NUEVO ATRISCO | MAJOR SITE PLAN AMENDMENT DRB COMMENT RESPONSES

NUEVO ATRISCO DRB Comment 6.24.2022 Responses					
Commenting Agency	Action	Date Received	Comment	Applicant Response	Applicable sheets
NMDOT	PR-2018-001405 Site Plan PR-2020-003847 Plat	6.24.2022	NMDOT does not have any comments at this time	No response necessary	-
AMAFCA	PR-2020-003847 Plat	6.24.2022	No adverse comments	No response necessary	-
MRMPO	PR-2018-001405 Site Plan	6.24.2022	MRMPO has no adverse comments	No response necessary	-
	PR-2020-003847 Plat	6.24.2022	MRMPO has no adverse comments.	No response necessary	-
ABCWUA	PR-2018-001405 Site Plan	6.24.2022	Availability Statement #211219 has been issued and provides the conditions for service. The availability statement indicated a fire flow of 1,725 gpm whereas the provided fire one plan in the DRB submittal indicated a fire flow of 2,000 gpm. Please confirm. A new request for availability may be required to account for the increase in fire flow.	Civil is coordinating with ABCWUA and has submitted a new water availability statement

PR-2018-001405 Case Description: Amendment to Site Plan | SD-2022-01115, VA-2022-00165 Sidewalk Wavier | PR-2020-003847 Case Descr

D3 NORTH ELEVATION
1/8" = 1'-0"

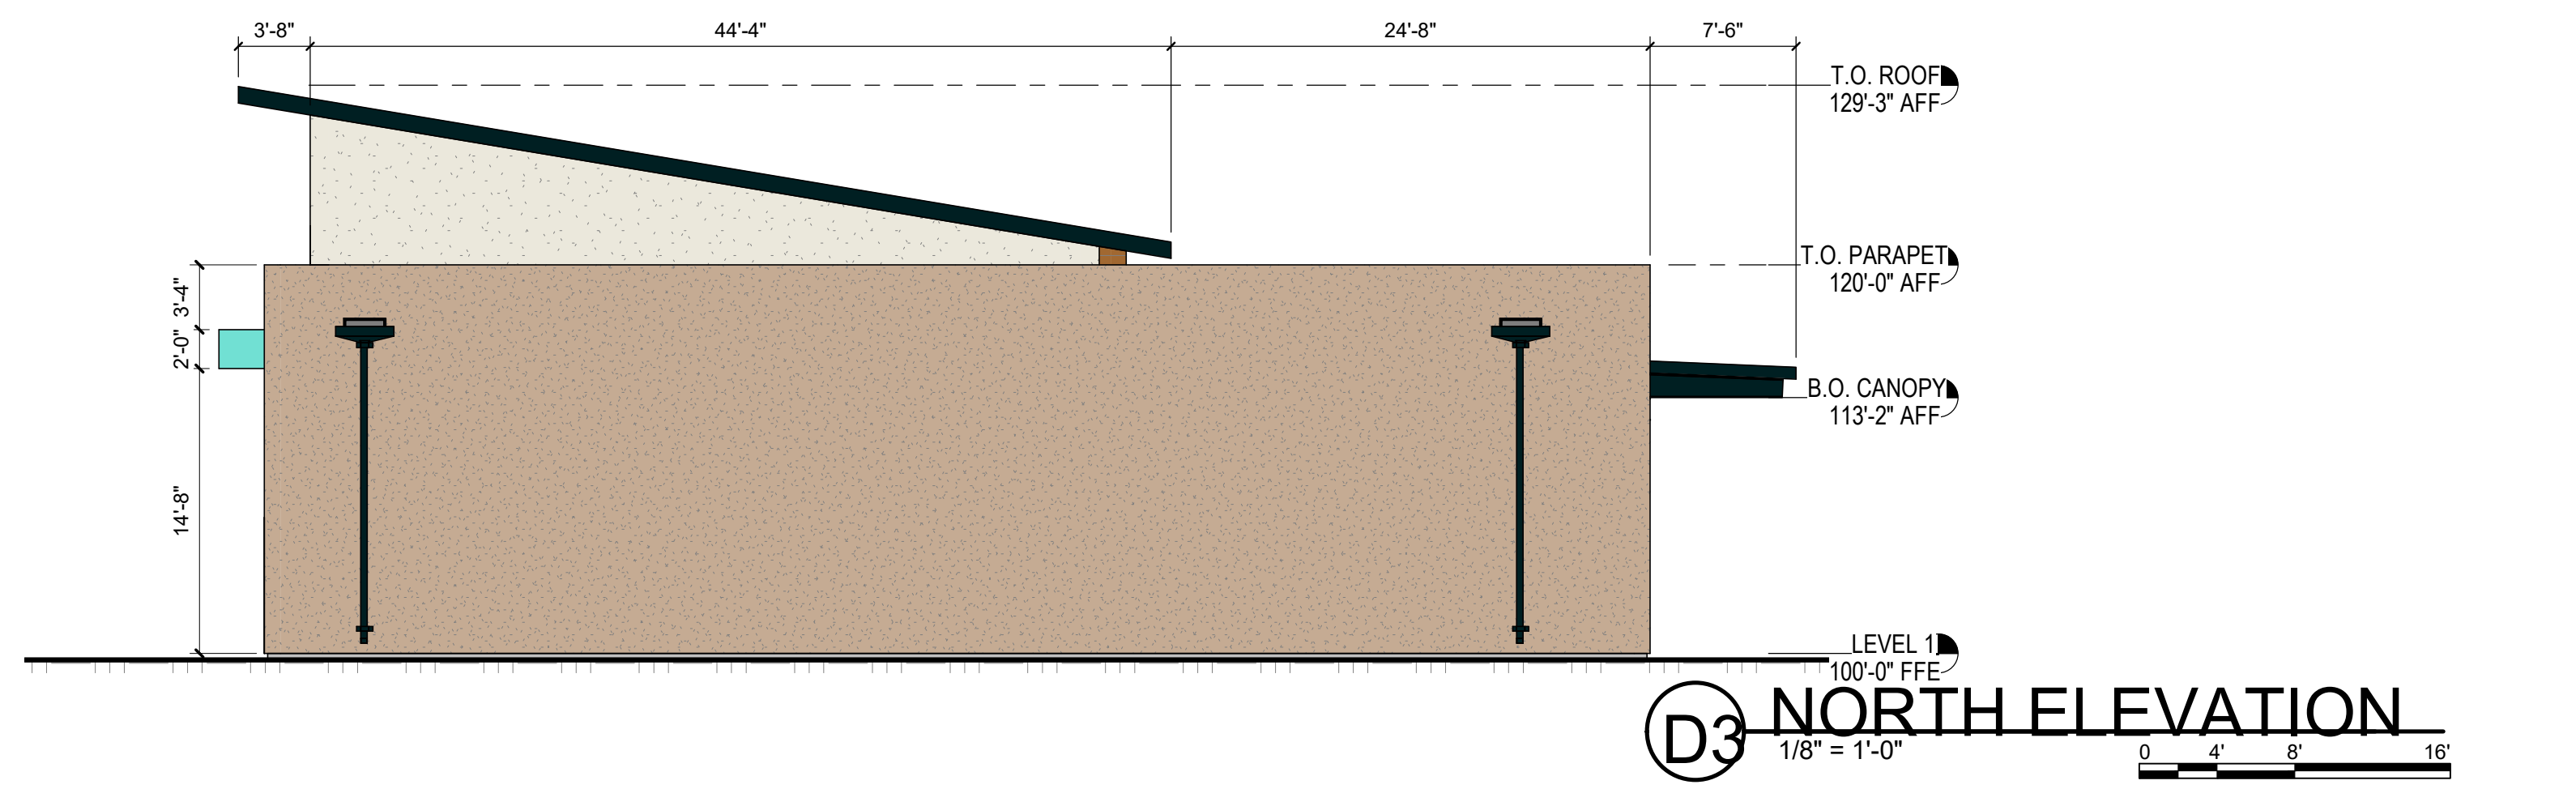
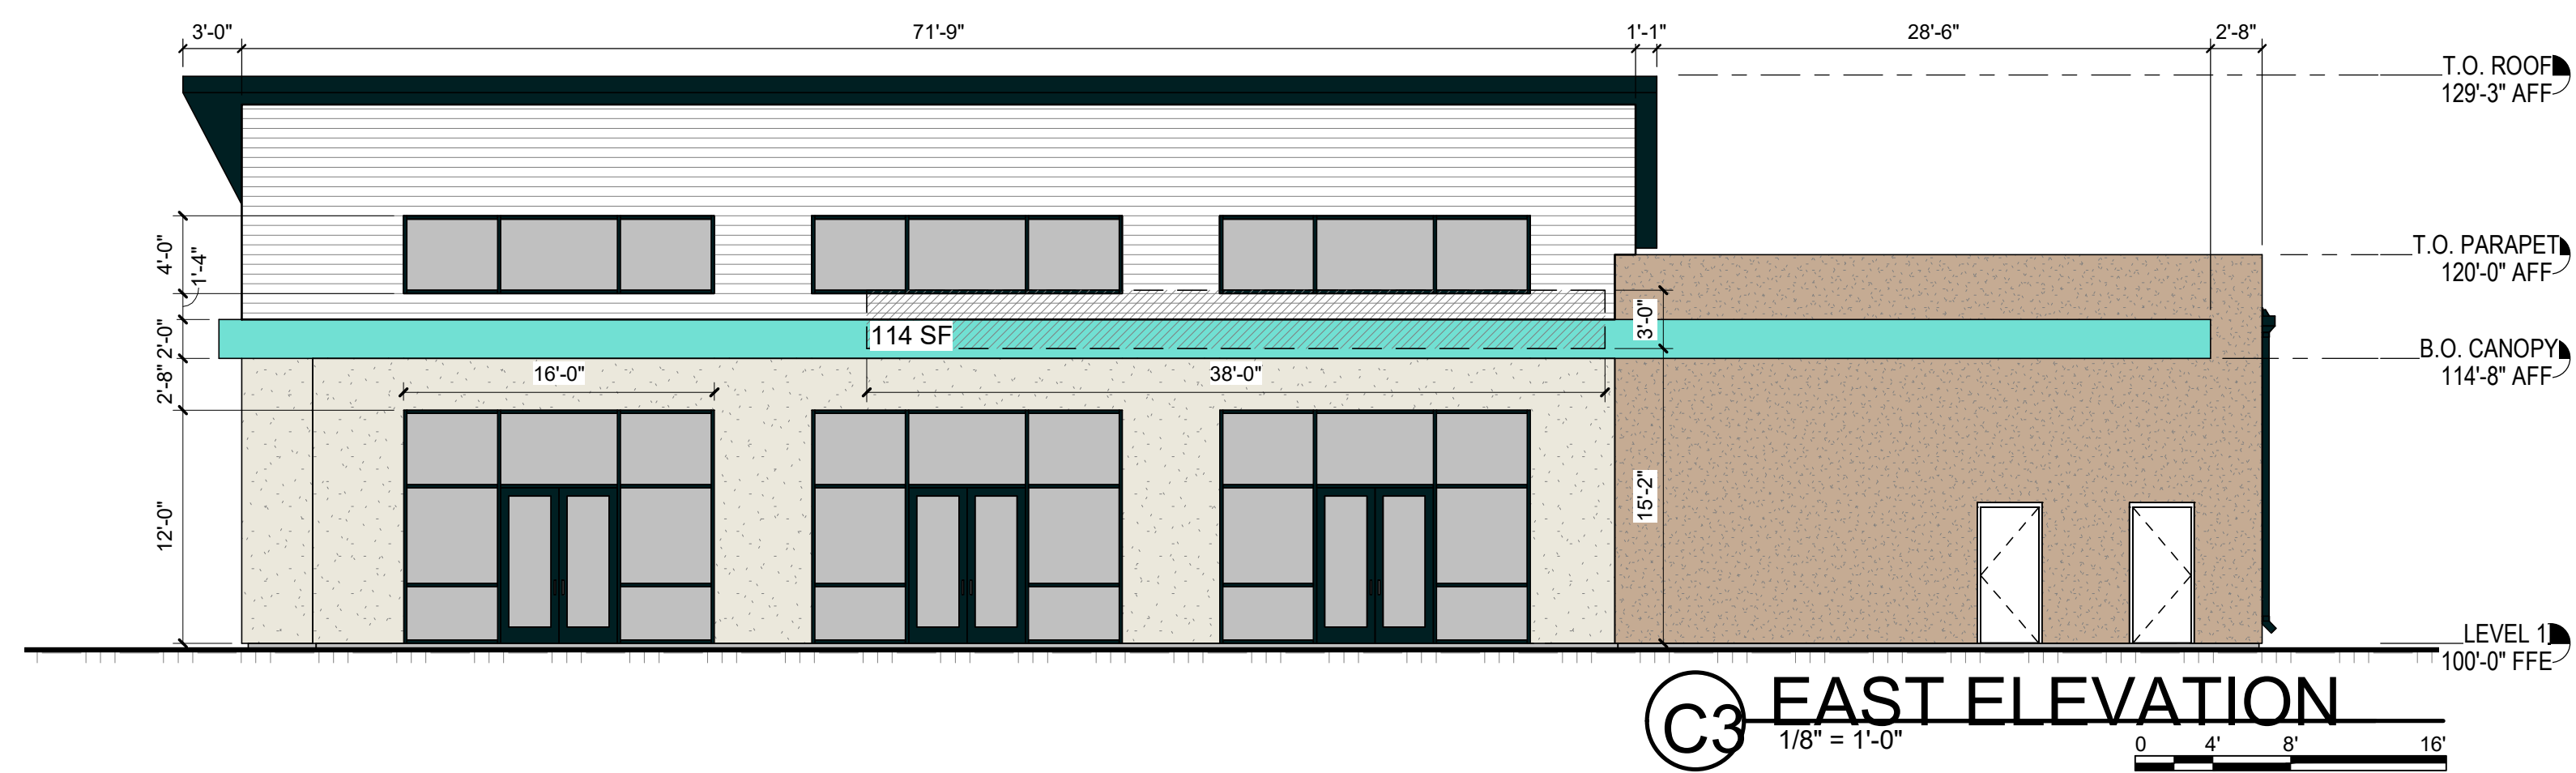
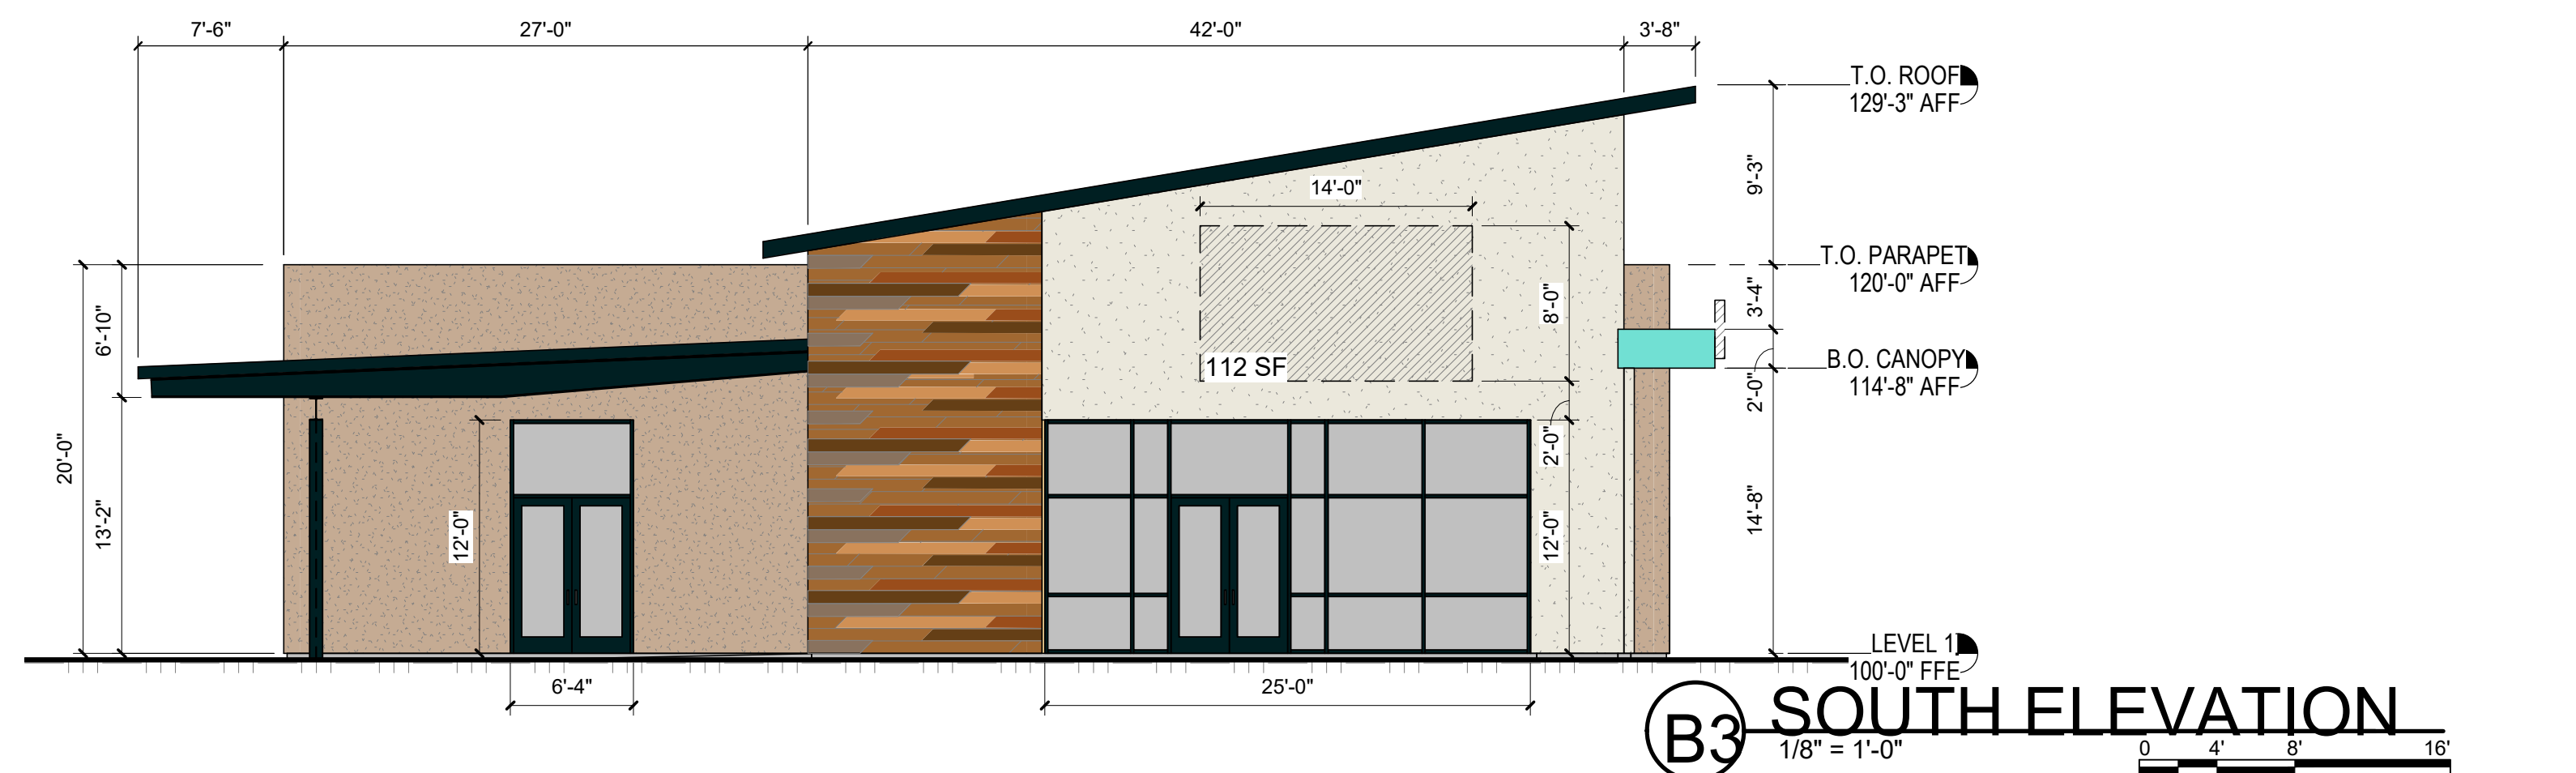
Planning	PR-2018-001405 Site Plan	6.24.2022	Please identify the front (is the front Central Avenue?), side and rear of the buildings and show setback measurements on the Site Plan for compliance with Table 5-1-2.	Yes, Central Avenue is the front, Unser is the side and the property line abutting the apartments is the rear. SDP1.1 was amended to lists required setback in Project Data, identification about front/side/rear was added.	SDP1.1
Planning	PR-2018-001405 Site Plan	6.24.2022	Elevations should show a measurement for the total building height of each building even though it is clear that buildings will comply with 65 foot height allowance for a Premium Transit area.	The elevation sheets SD5.1, 5.2 and 5.3 indicate a T.O. ROOF that shows the total building height measurement.	SDP5.1-5.3
